OBJECTION to BR/194/17/PL

I object to the planning application to take down the Forshore office and replace it with two buildings.

DRAWING
Proposed Toilet Elevations

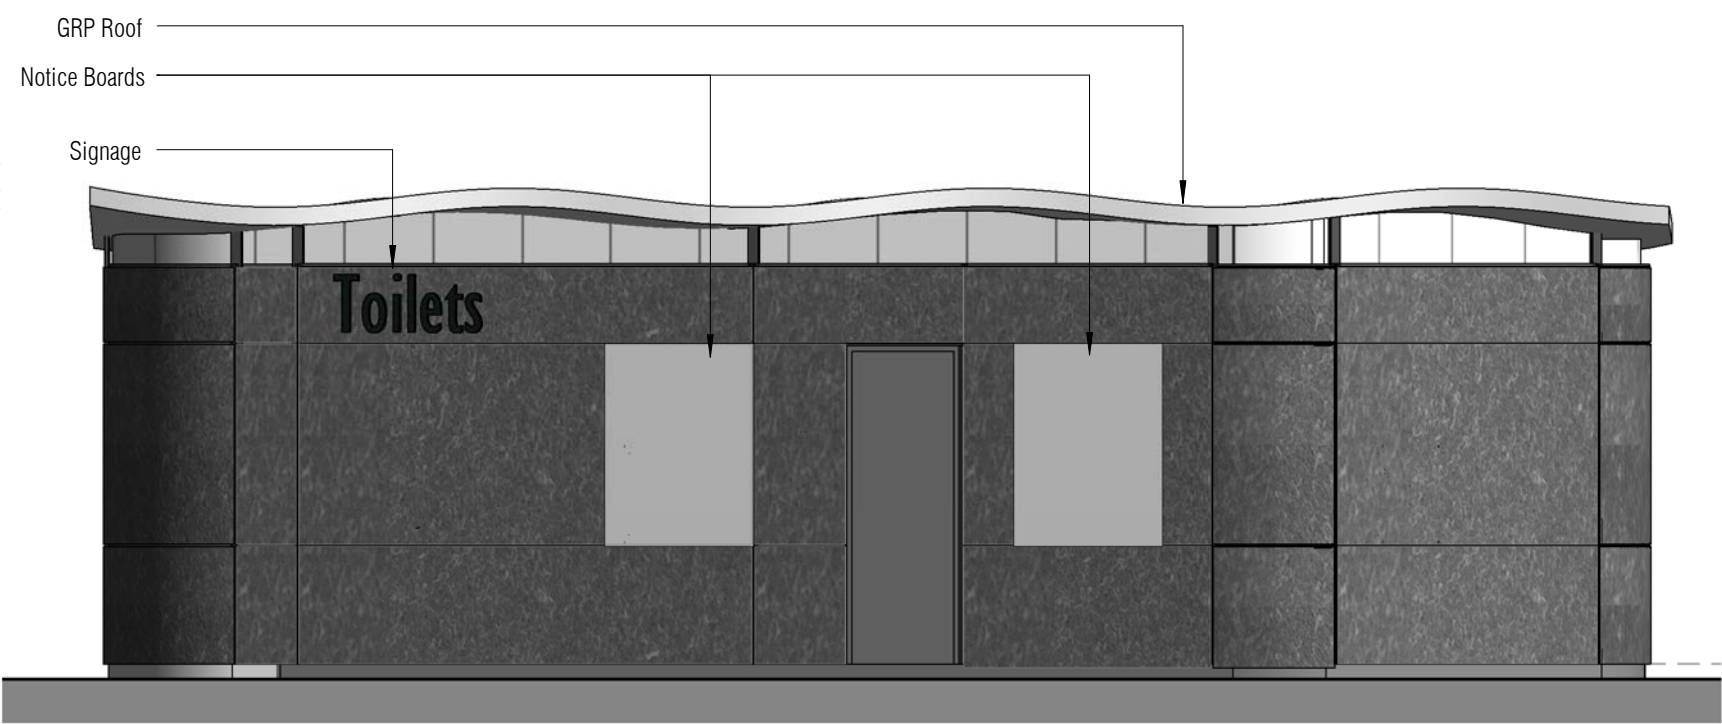
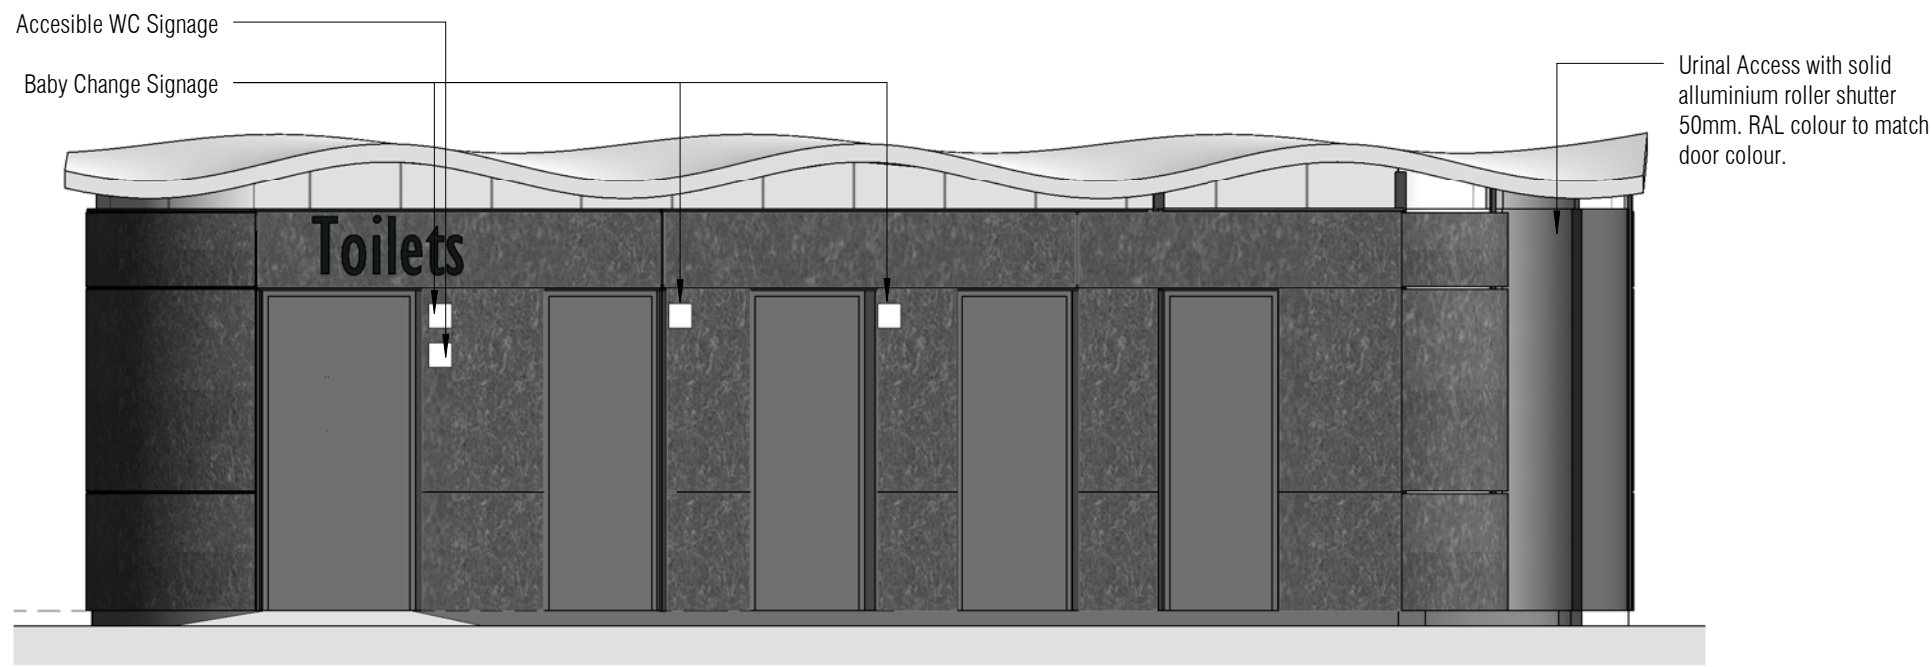
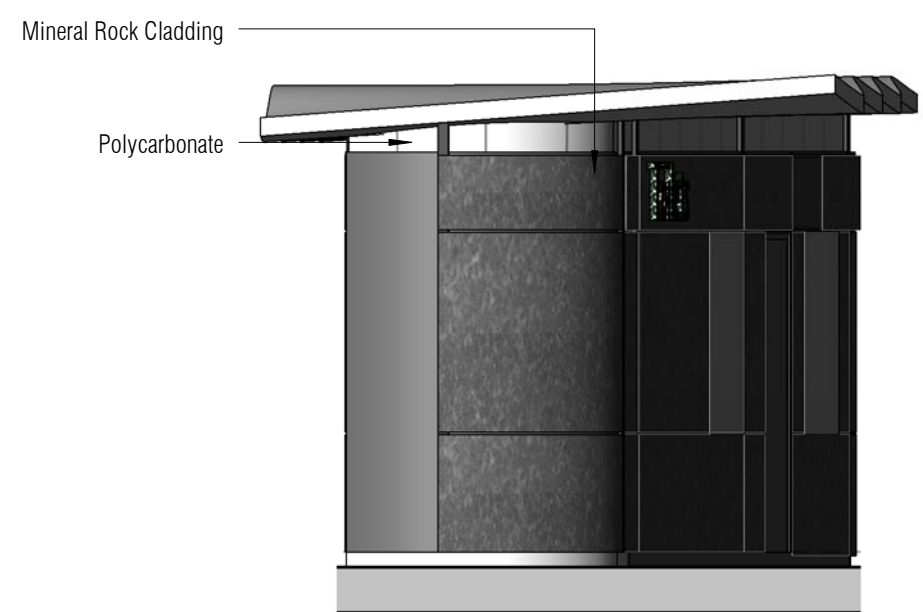
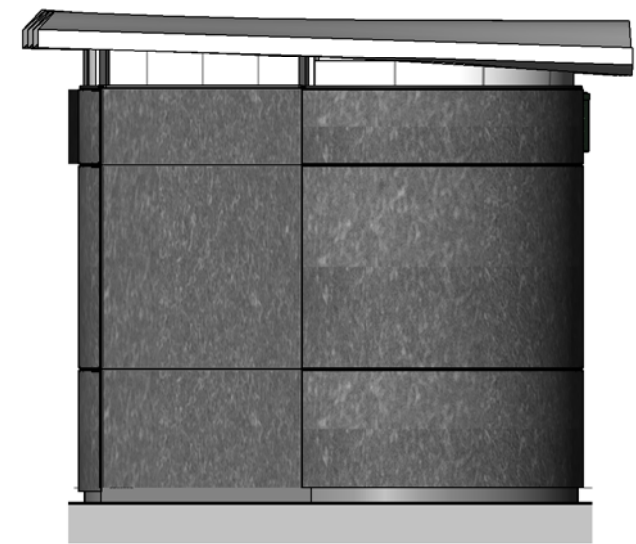
I already look at the back of the Coffee Cup 'shed'. The customers look directly into my apartment. If a toilet block is built as planned, my view will be badly affected. My privacy will also be affected by not only the café customers but the toilet users who will look directly across at my windows

I thought the café was bad enough, but a toilet block is even worse.
